3/2011/0896

**Planning Application, Ribble Valley District
3-09-0532 Old Methodist Chapel, Lower Chapel Lane, Grindleton**

I am recommending refusal of this application on highway safety grounds as it does not provide satisfactory off street parking provisions and the approaches to the site demand safety improvements that cannot be achieved from within land under the Applicant's control.

Proposed Block Plan
Scale 1:100 @ A1

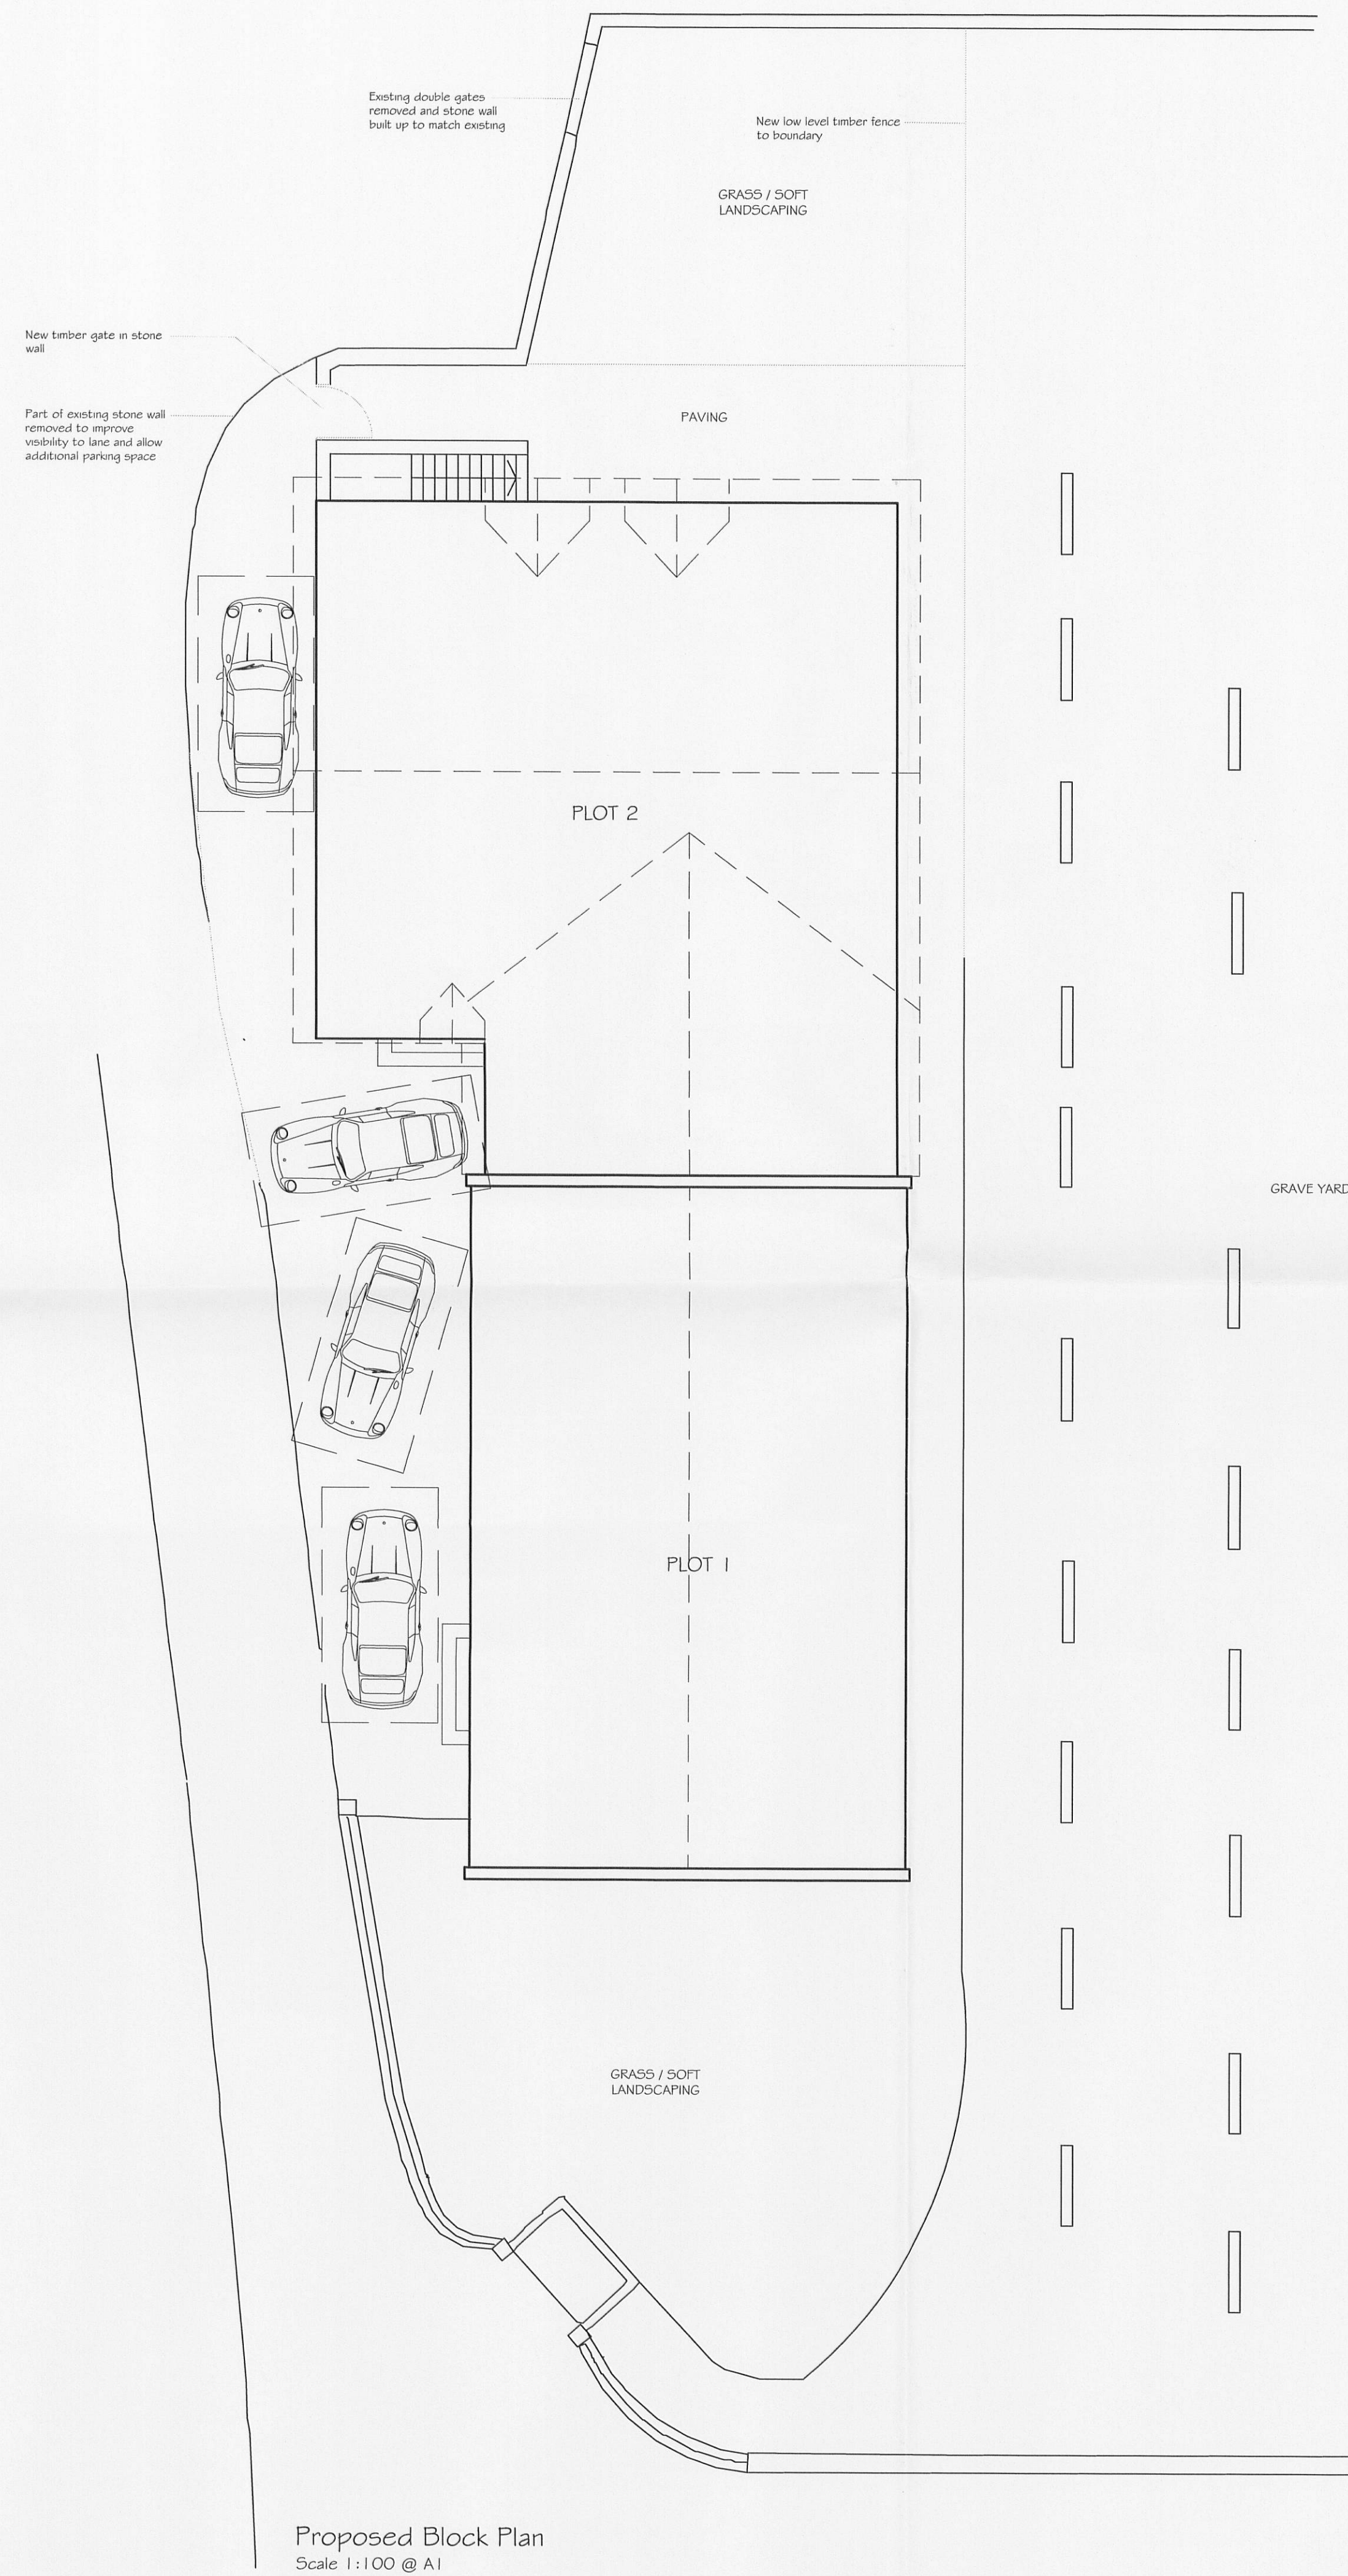
Access for vehicular traffic to this site at the junction of Lower Chapel Lane and Back Lane, Grindleton is not ideal due to the narrow width of the approach from Main Street, the limited manoeuvring space to the four off street car parking spaces identified on the site plan and the limited parking available on the adjacent unadopted roads in the immediate vicinity of the site.

My concern, therefore, relates to the viability of the four car parking spaces being proposed, as the present arrangement does not appear to secure four accessible spaces.

Considering these spaces, working west to east, the first and second spaces will require the motorists to reverse either to or from these spaces, with the likelihood being that the vehicle will be reversed to/from Back Lane or will travel further up the lane to turn at a field gate. This is not a satisfactory means of safely accessing these spaces. Furthermore, Back Lane

is an unadopted road in a poor state of repair that also serves as a significant pedestrian route for residents.

The third space is of substandard dimensions, certainly below the 5.0m minimum length and would result in a family saloon overhanging the carriageway to the detriment of the safe movement of passing traffic.

The fourth space, like the first and second, would require motorists to carry out an unsatisfactory manoeuvre to gain access.

I would be grateful if the applicant would reconsider the proposed parking arrangements and provide a layout that complies with some basic criteria for the creation of safe parking spaces.

For example, all of the car parking spaces along the length of the frontage should comply with a standard parking module of 2.4m by 4.8m, while end-on parking should have a minimum depth of 5.0m. The spaces provided must insure that all vehicles can park fully off the highway, without the potential for vehicles overhanging the footway and causing a hazard to pedestrians and other road users.

The layout of the four spaces should satisfy the basic requirement that vehicles can enter and exit in a forward gear. There is a potential hazard where any vehicle has to reverse onto the highway and this is heightened in this instance due to the lack of any adjacent footway, which results in an additional hazard for pedestrians.

The creation of a small parking area on farm land immediately to the east of the existing building and served by an existing field gate would provide a reasonable solution. Similarly, the use of part of the land fronting the church could allow the creation of a suitable manoeuvring area.

Either of these provisions would minimise highway safety concerns by reducing the potential manoeuvring and subsequent conflict at the front of the site and provide for vehicular access in a forward gear, to and from the site.
